From: Anthony Kindred <[REDACTED]>
Sent: 07 November 2024 11:54
To: Outer Dowsing Offshore Wind
Subject: your reference number 20048310

Response to applicants written answers

RR-084

Drawing Title: LOCATION 013 - WASH ROAD / CRAVENS LANE
INDICATIVE PASSING PLACES

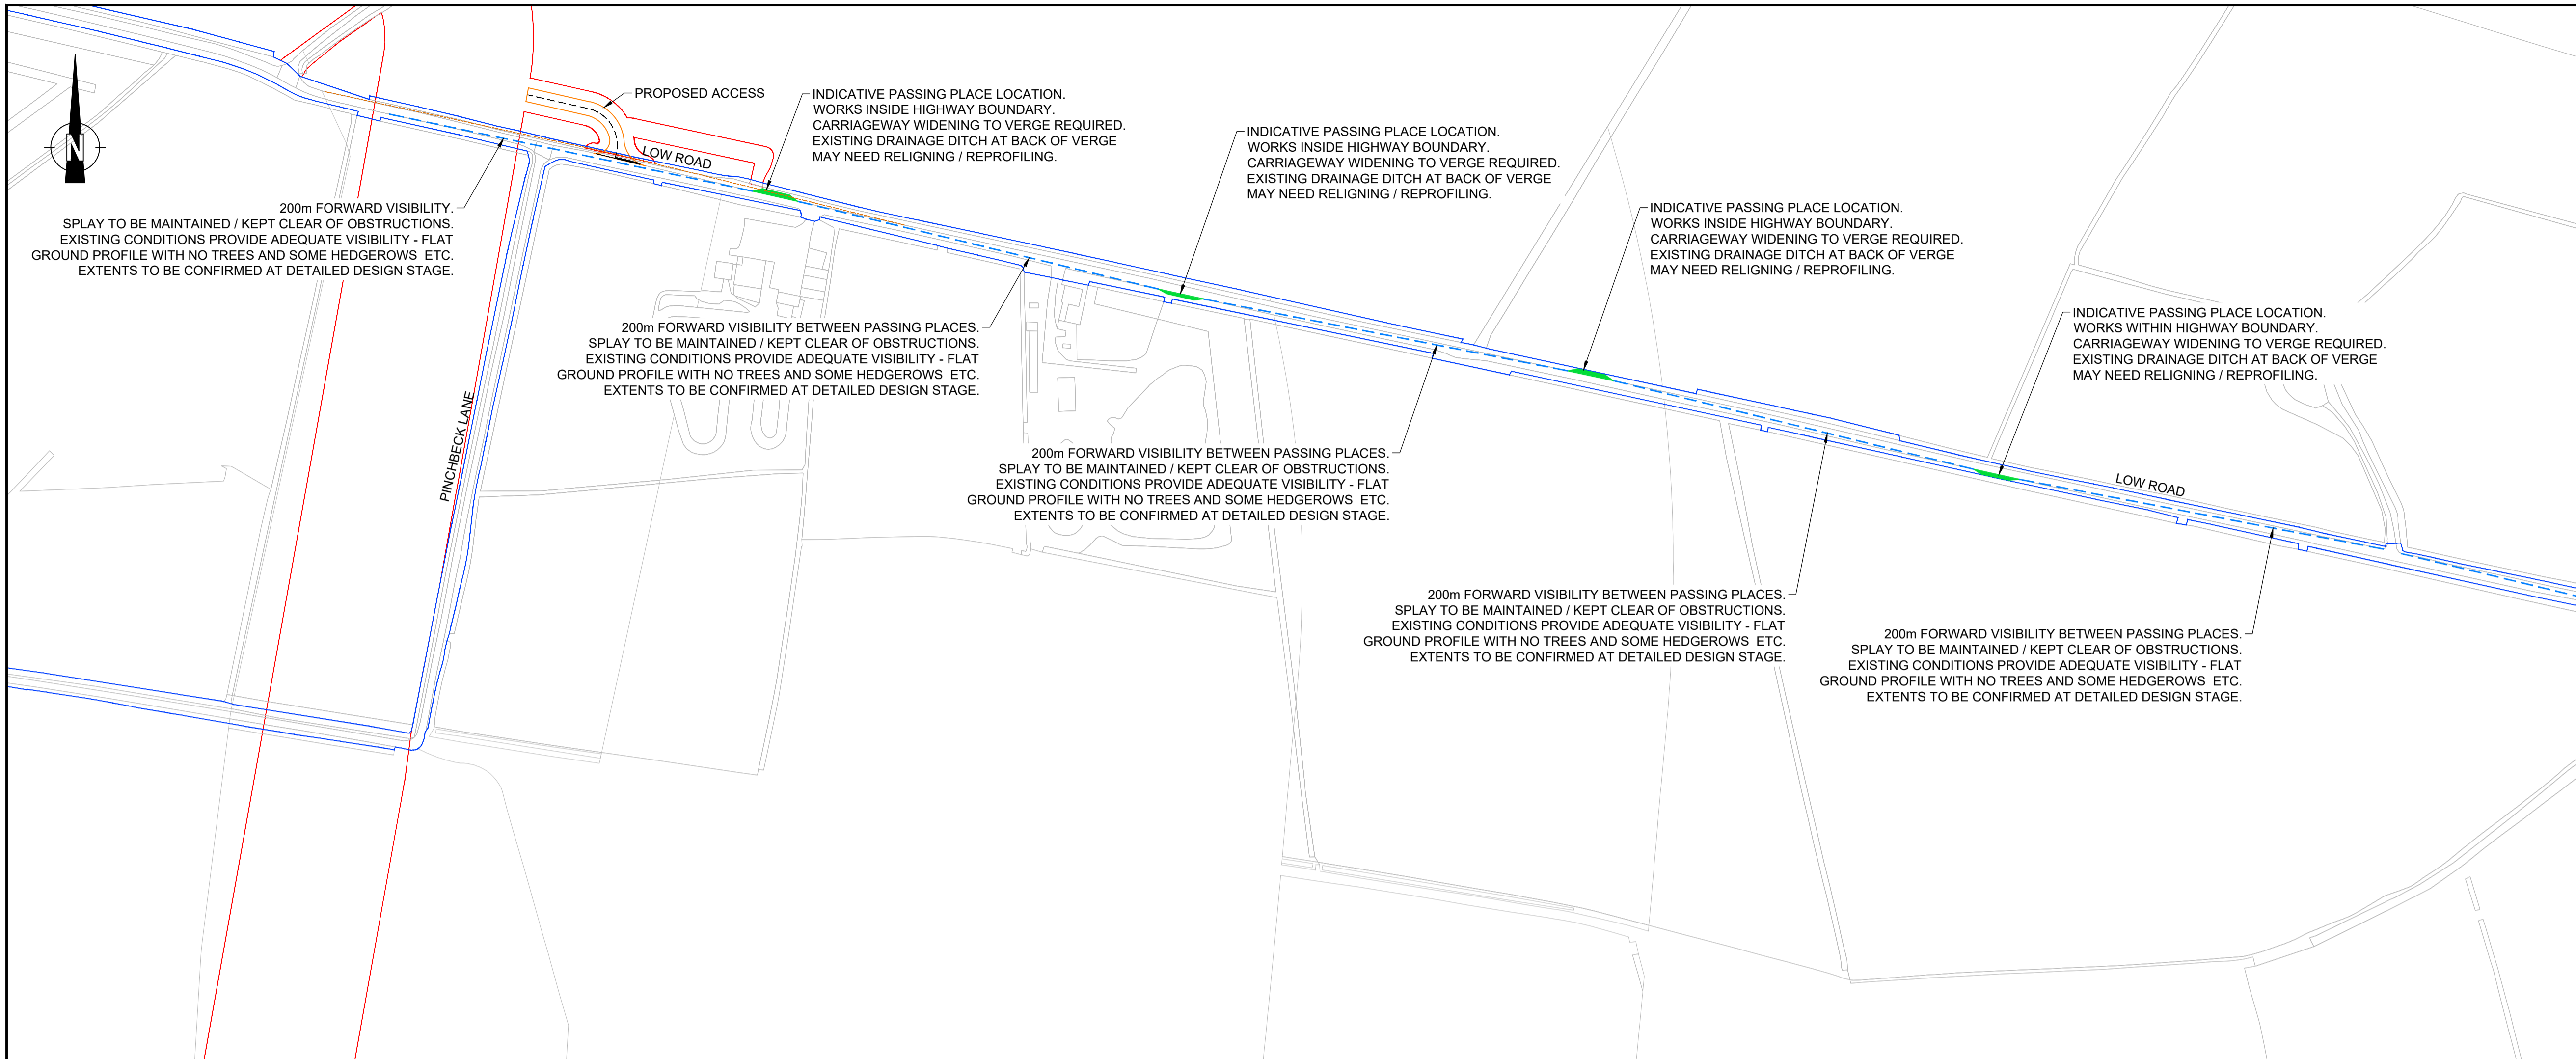
1. Whilst the addition of passing places is a positive step I think that as Wsh Road at Present is a national speed limit of 60mph it should be reduced to 30mph during the construction phase
2. I understand full access will be maintained to the Almshouses
3. The Almshouses are very fragile especially the roofs so will need constant monitoring during construction and a plan will be needed if any damage needs attention.
4. The fields in Fosdyke surrounding the construction corridor are usually flooded during the winter and compaction by construction works would cause run off onto roads and homes unless drainage is put into place
